DEVELOPMENT FACILITATION TEAM

TRANSPORTATION DEVELOPMENT

Project Number: 2025-020158

Adjust lot line  
1619 Solano NE

EXISTING SITE CONDITION

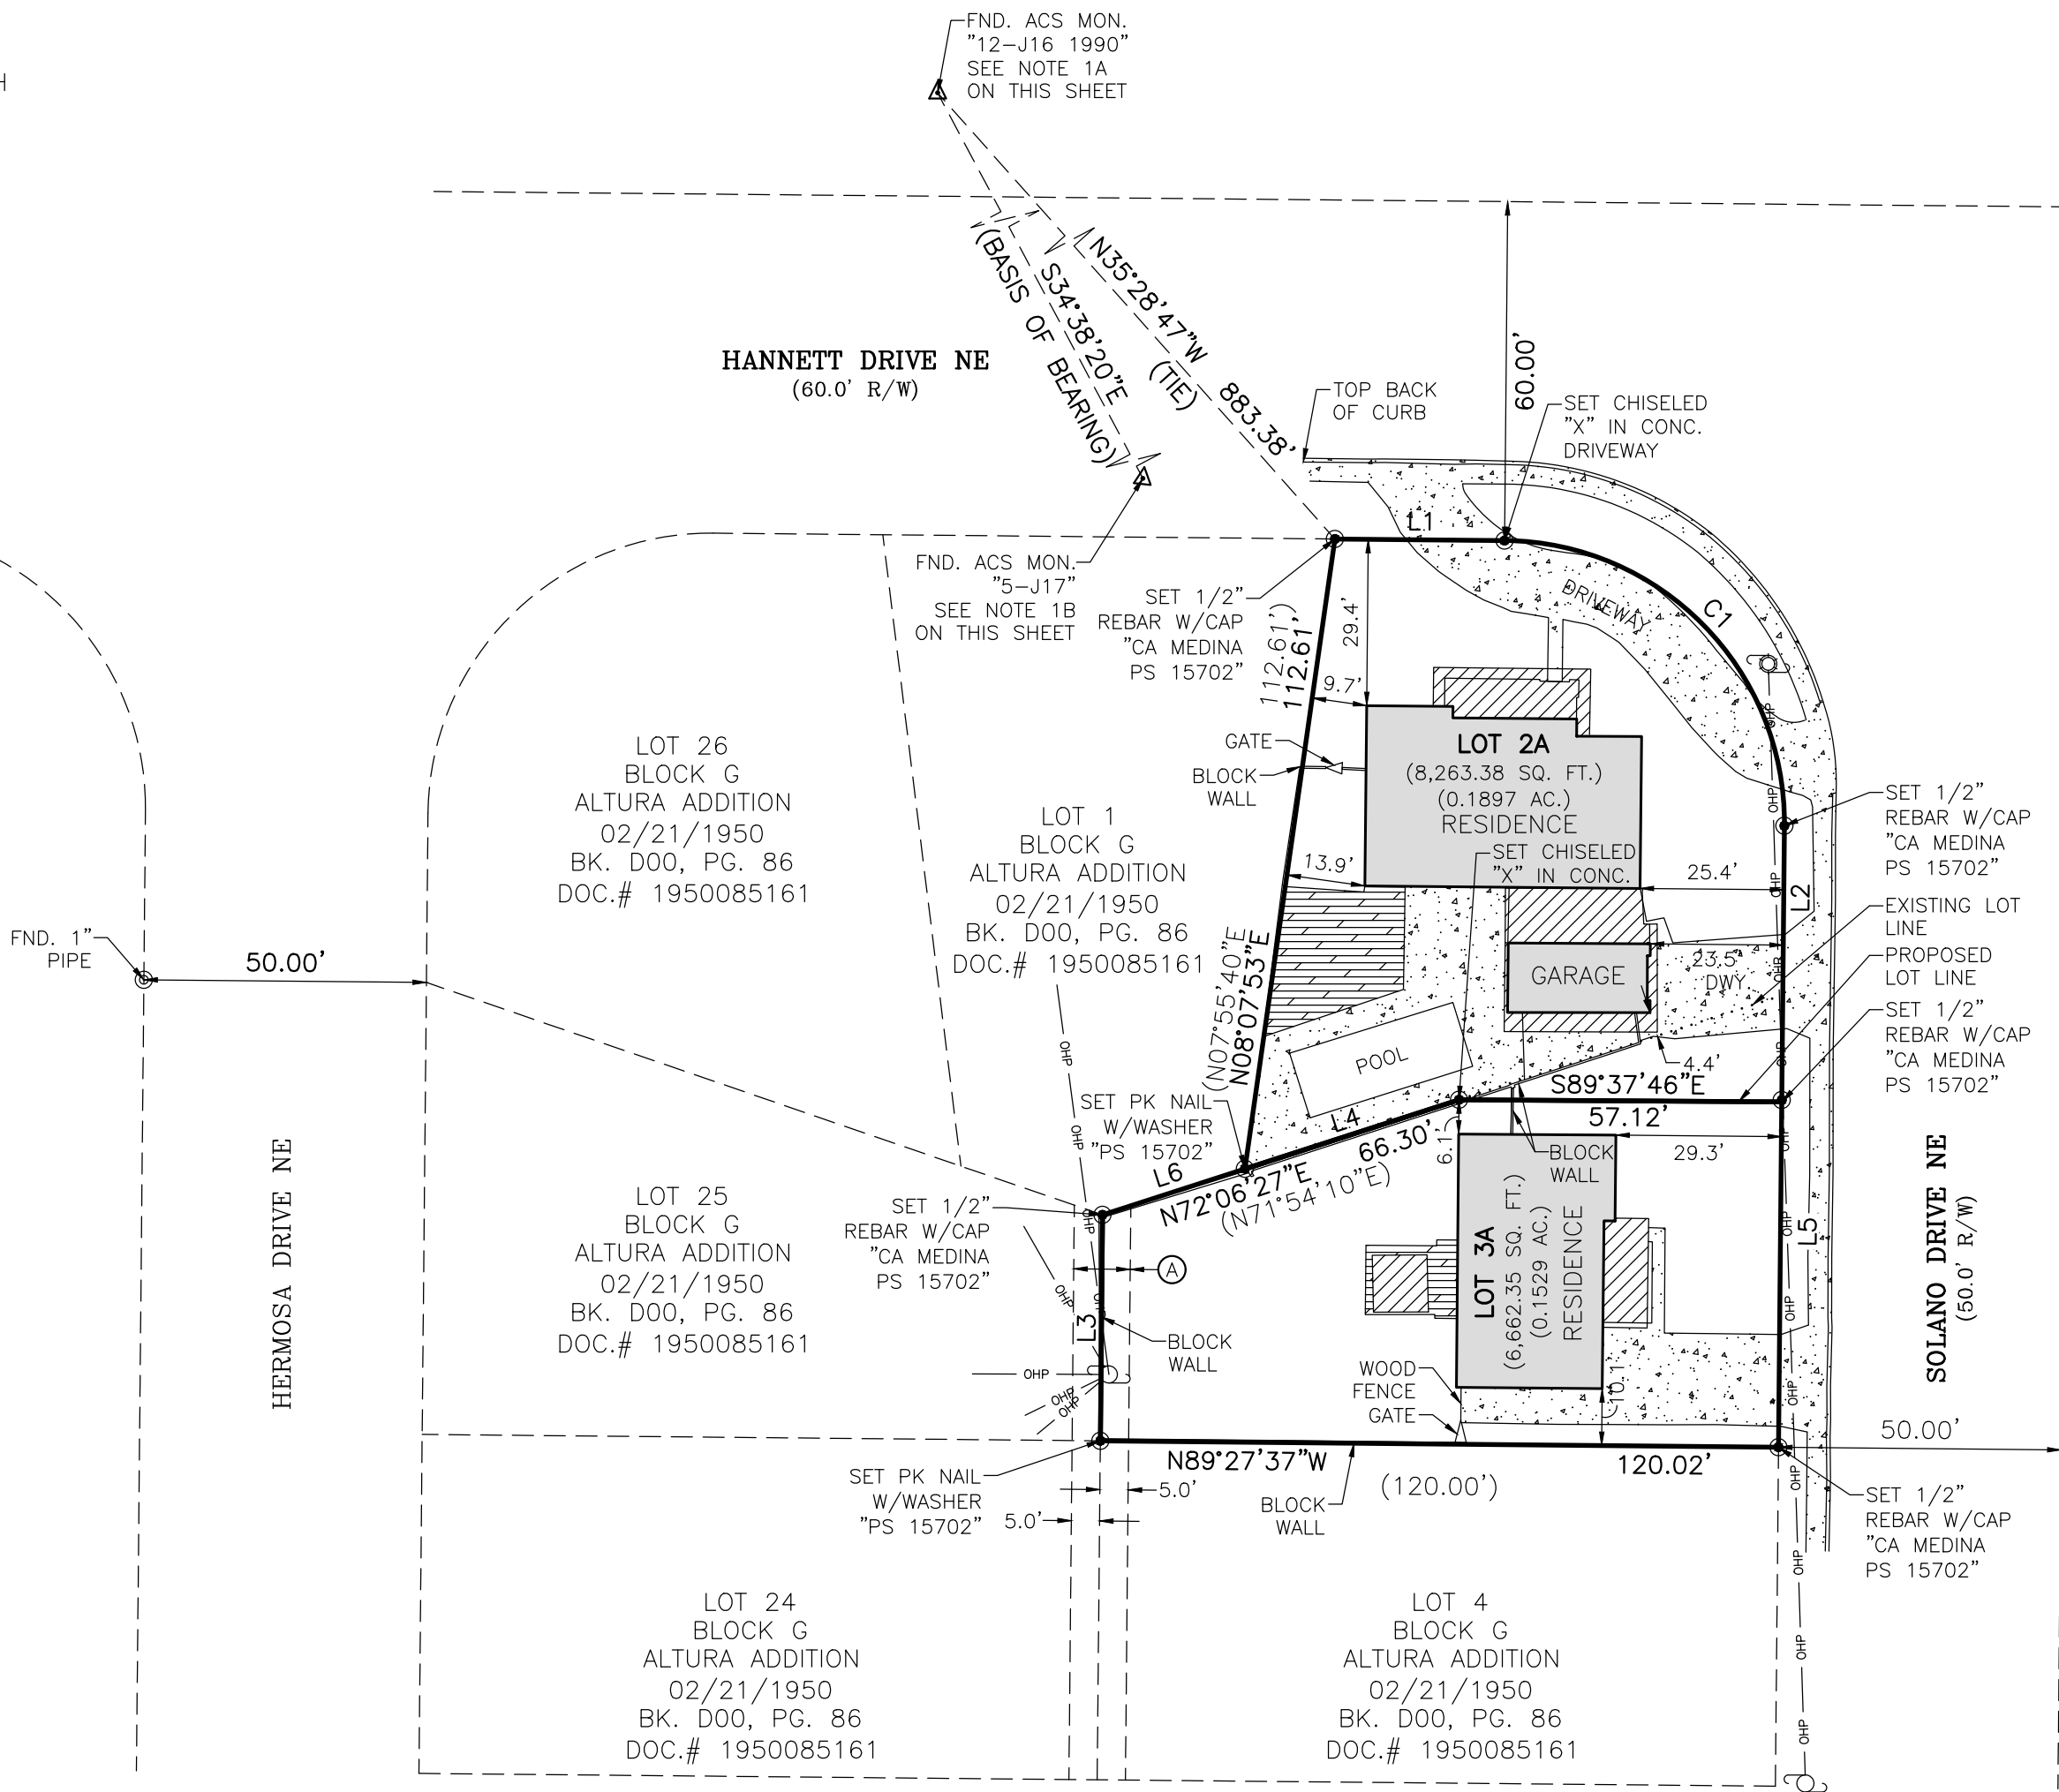
- 1- Solano and Hannett are local streets require 5' sidewalk and 4'-6' Landscaping Buffer. Drawing does not show the sidewalk widths, if they are less than 5', they need to be widened to 5'.
- 2- Any future development will require an approved TCL prior to site plan or building permit. Also, a Traffic Scoping Form would need to be submitted to determine if a TIS would be required.
